## About the application

Application number: 2024/92167	
What is the application for?:	Variation of condition 1 (plans) of previous reserved matters approval 2017/9019
Address of the site or building:	Land off, Edgerton Road, Edgerton, Huddersfield, HD3 3AA
Postcode:	BD19 5LQ

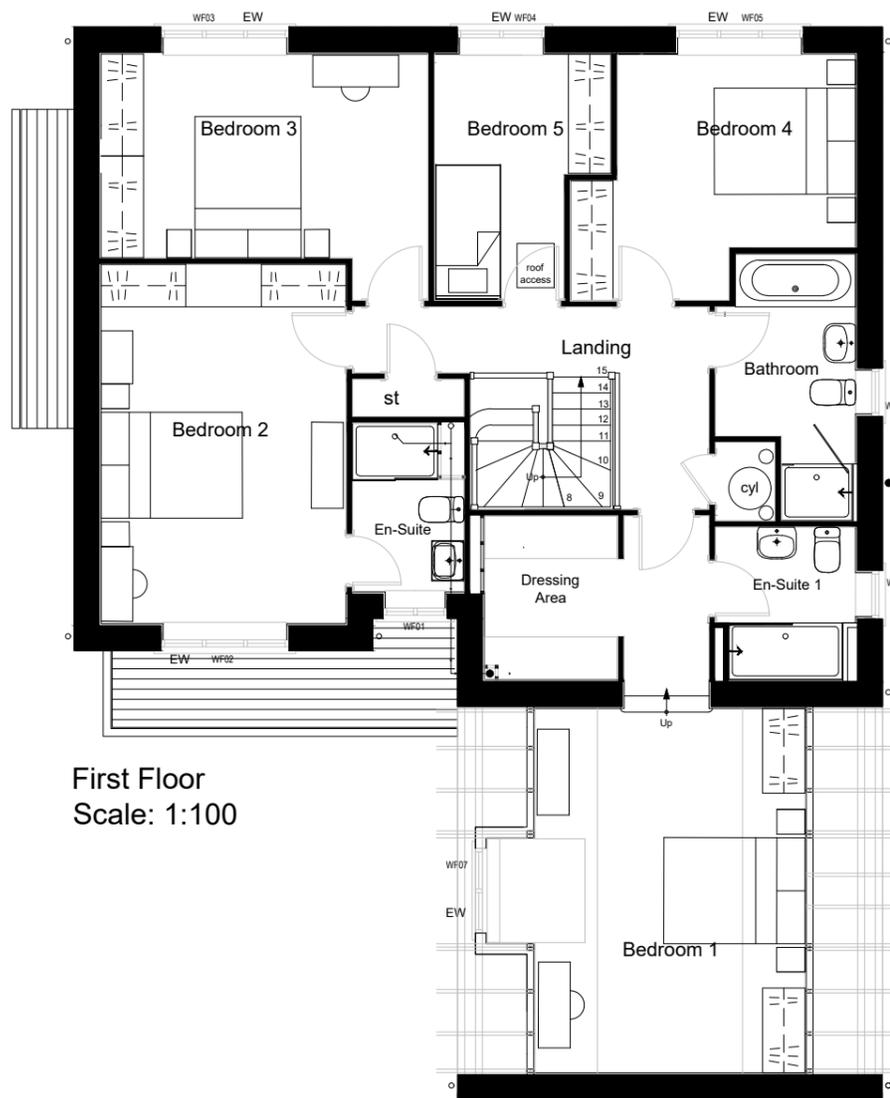
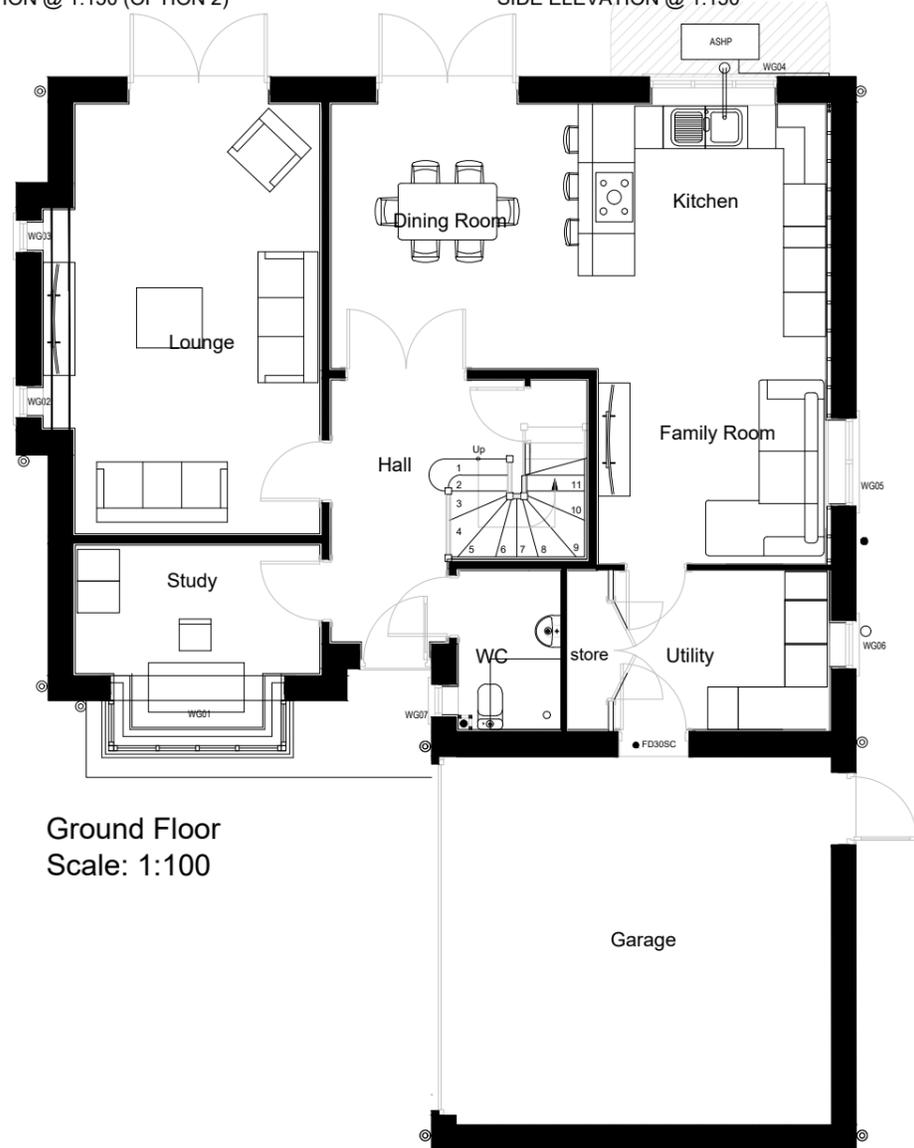
Type of comment: An objection	
Do you wish your comments to be published on the website anonymously?	<input type="checkbox"/> Yes
<p>This application seeks to amend condition 1 planning application 2017/90190. The plans for the various house types state they can be built of stone or artificial stone. This is contrary to condition 3 of 2017/90190 which states all houses must be built of natural stone, as the development is in the Edgerton Conservation Area.</p> <p>The 2017/90190 house plans state that the roof will be slate. The application house plans state that they will be roofed with "SLATE (ETERNIT RIVENDALE)". According to the manufacturer's website "Rivendale slates have a beautifully textured surface and dressed edges, combining the benefit of modern slate technology with the look of a natural slate". This is obviously artificial. The houses must be roofed with natural slate as originally planned, as the development is in the Edgerton Conservation Area.</p> <p>The applicant states in their submission that "The site has a long and complex history". Planning permission was given on appeal with various conditions and since then various applications have nibbled away at these original conditions. This is the latest.</p> <p>If a development is approved, then the Section 106 amounts must be revised to reflect current values as they are clearly inadequate and out of date.</p>
